Please ask for: Mrs D Johnson
Email: daun.johnson@arun.gov.uk
Telephone: 01903 737762
Our Ref: Y/10/22/PL
Your Ref:
Date: 31st January 2022

Application for Planning Permission

Development: Erection of 15 No dwellings (including 4 No affordable units) with associated access, parking, landscaping, drainage and public open space (additional units to those approved under application Y/123/21/PL). This application may affect the setting of a listed building, affects the character & appearance of the Church Lane Conservation area, affects a Public Right of Way and is in CIL Zone 2 and is CIL Liable as new dwellings.

Location: Land To The South Of Ford Lane And East Of North End Road Yapton BN18 0DS

Title:
SITE LOCATION PLAN

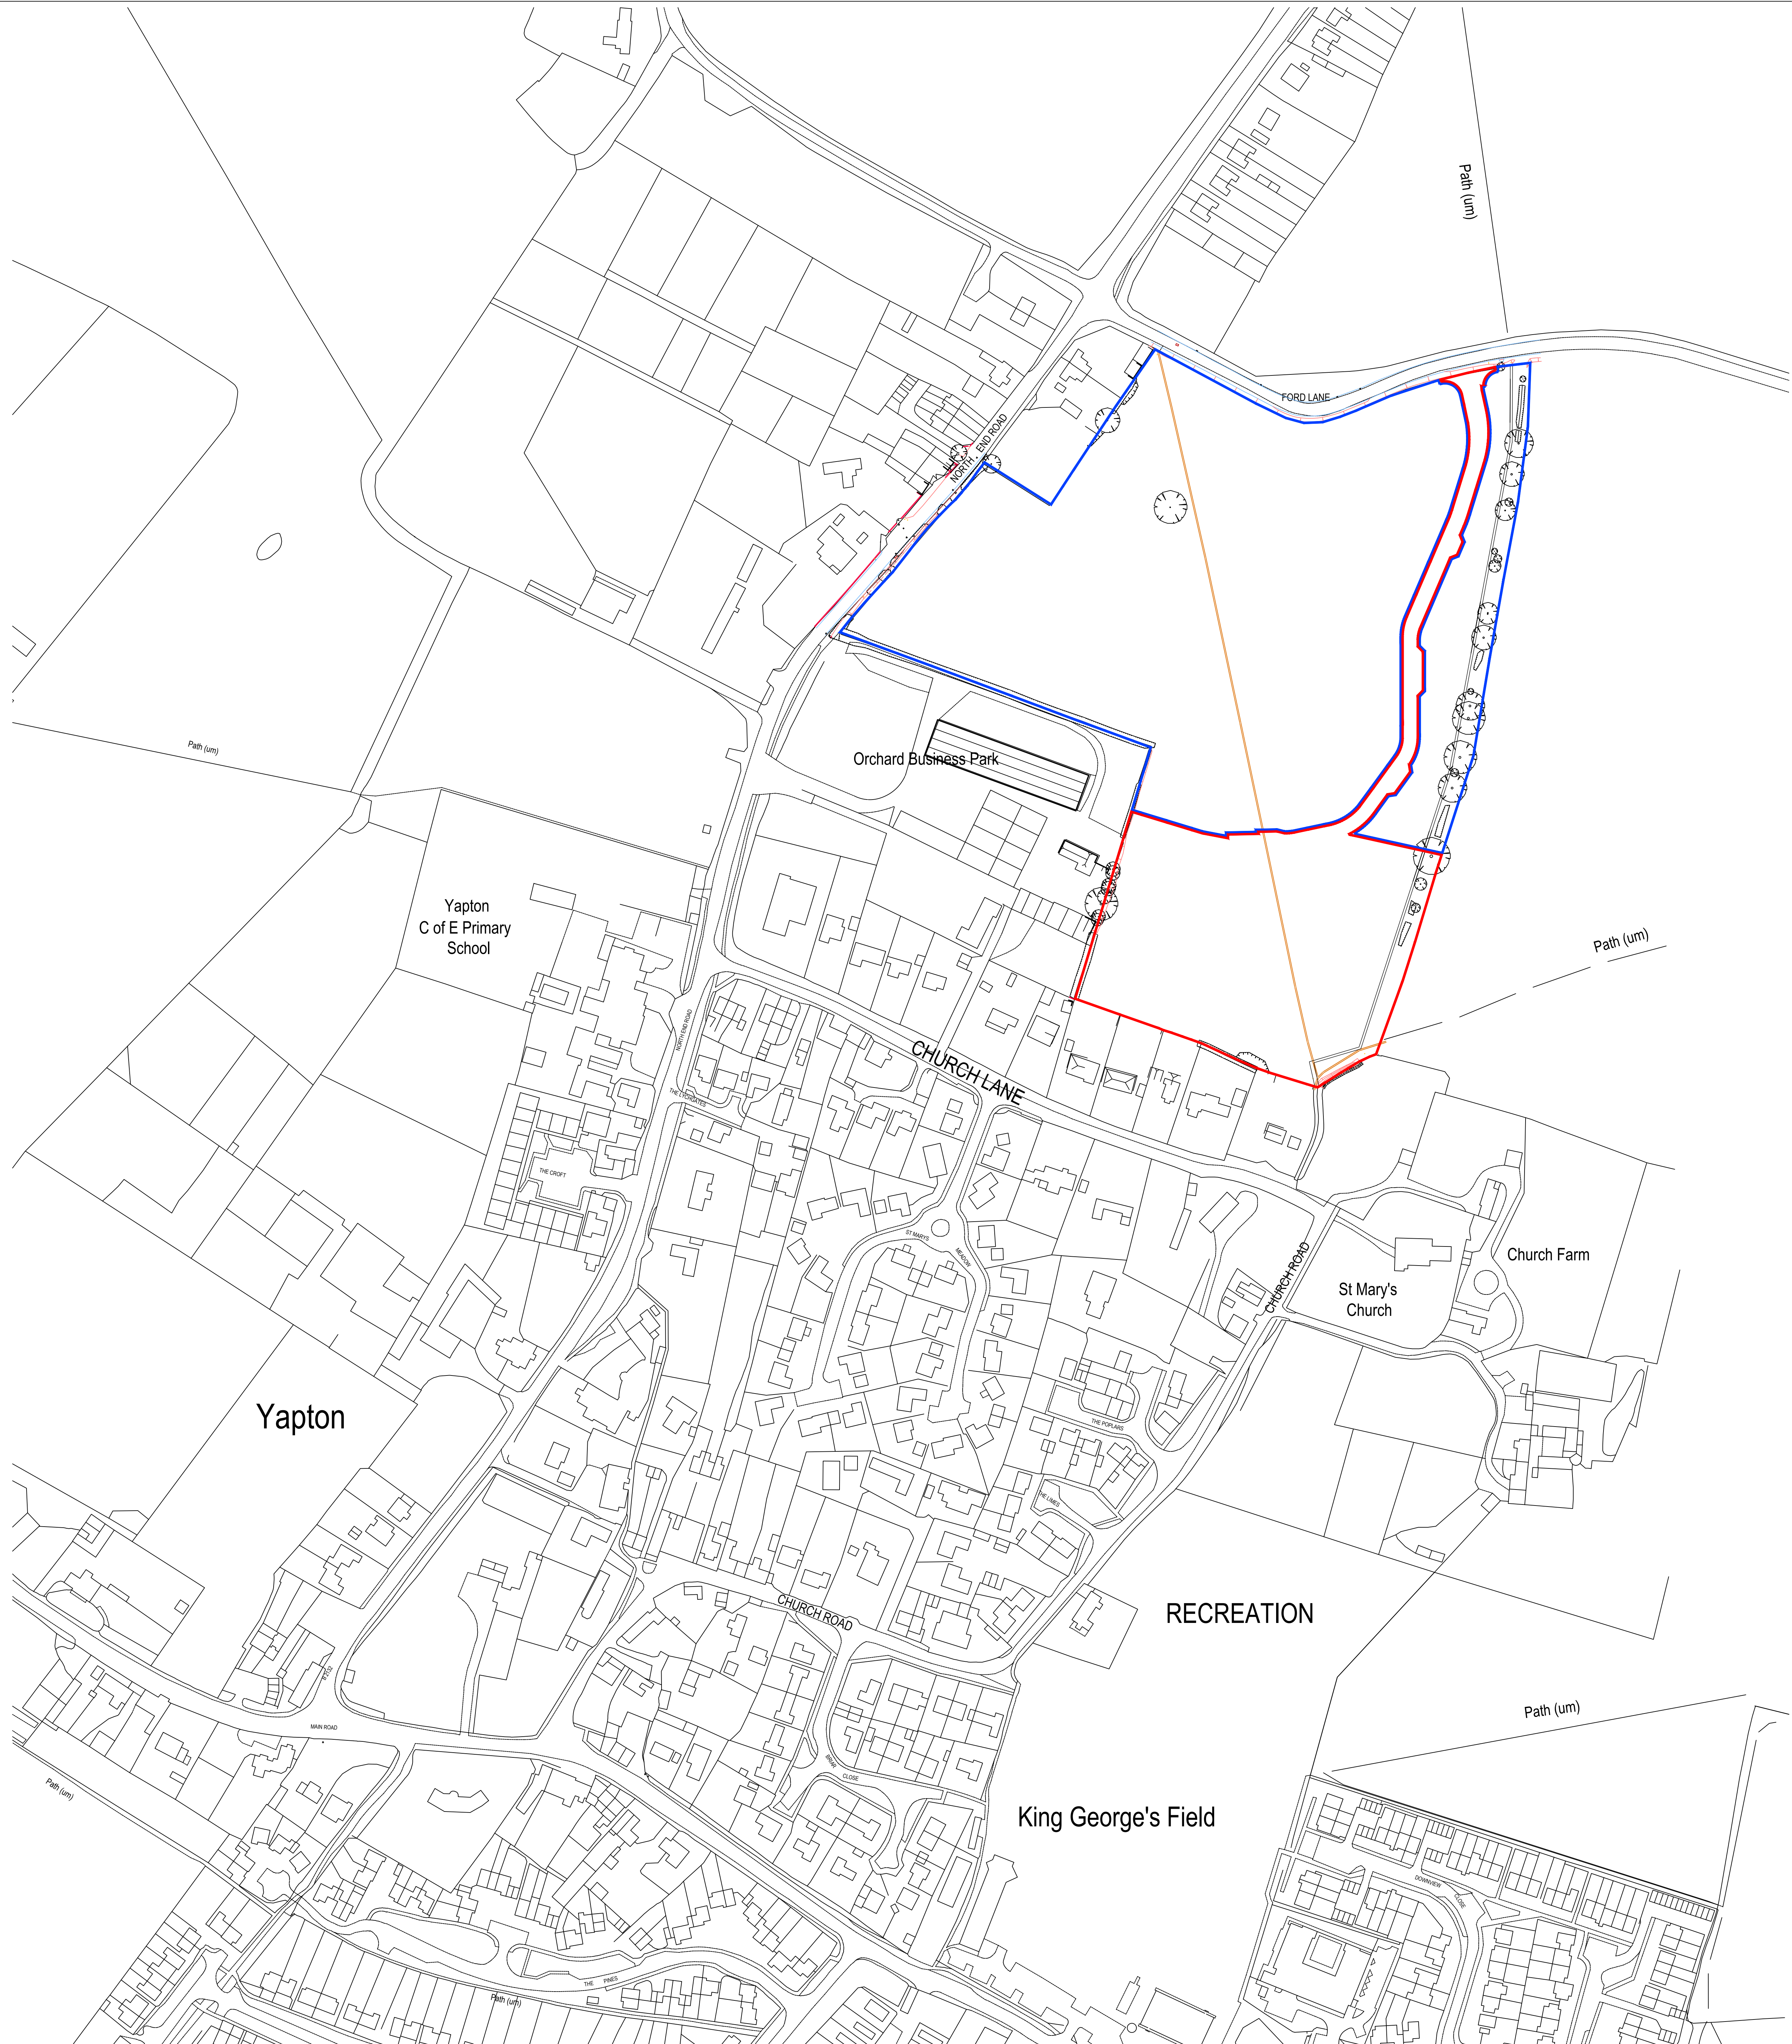
Please show the access from Ford Road to the site within the red edge.
